Subject: FW: FW: R/73/20/DOC - Condition 6 of R/201/19/PL - 106 The Street, Rustington

Please see the comments of the environmental health officer below. It is now my intention to refuse the application by the end of this week. How long do you anticipate it will take to provide the additional information she is requesting?

Thank you for forwarding Anderson Acoustics' Pre-completion Sound Insulation Testing report (ref.: 4757_001R_1-0_BP, dated June 2020) and associated photographs.

Standardized level difference according to BS EN ISO 140-4

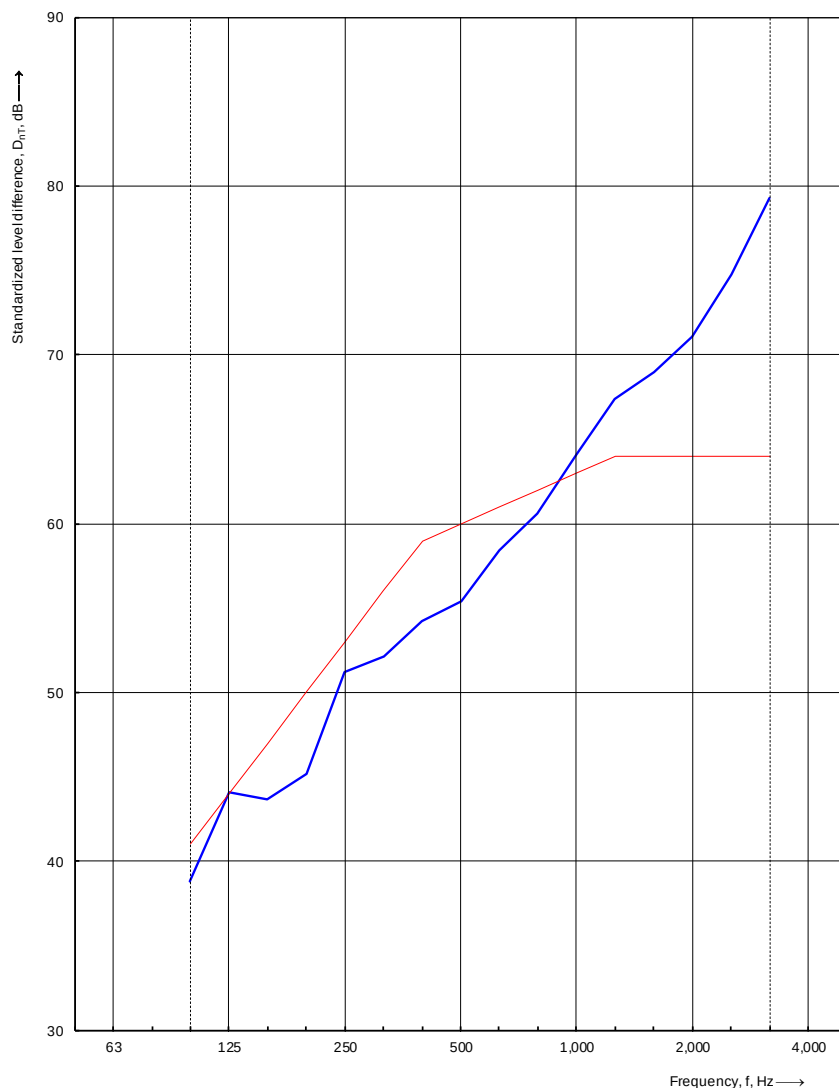
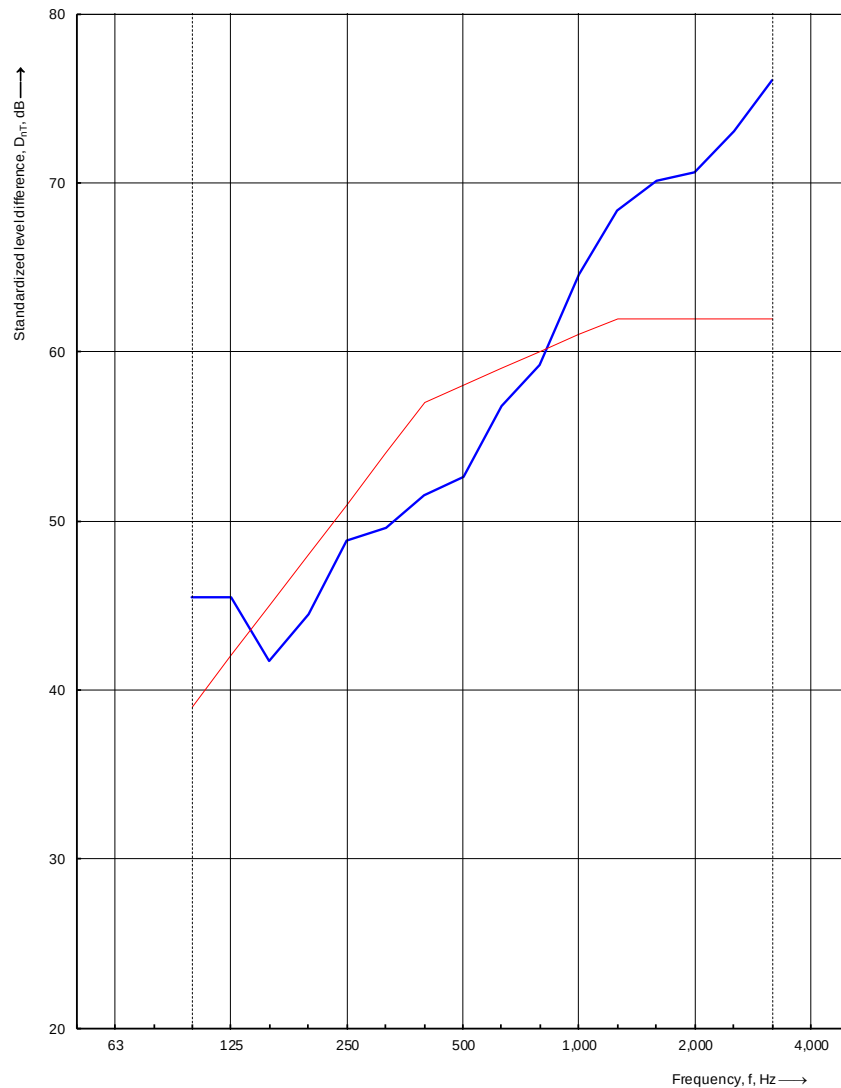
Having now reviewed this report, it is not possible at this stage to recommend that the relevant condition can be discharged. The report references Approved Document E which is a Building Regulation publication. Furthermore, it is my understanding that Approved Document E relates to residential properties and not buildings in commercial use.

As previously advised, this Department would expect that a suitably qualified, independent acoustician is employed to establish the location of the nearest noise sensitive receptor(s), calculate the likely sound levels (to include tonality, etc.) from the proposed use and ascertain whether this is likely to be problematic for the occupiers of the previously identified receptor(s). Based on this, an appropriate acoustic attenuation scheme can be designed. Once the local planning authority has approved the scheme, works can commence and once completed, a test shall be undertaken to ensure the scheme is effective. The submission received to date does not adequately address these requirements.
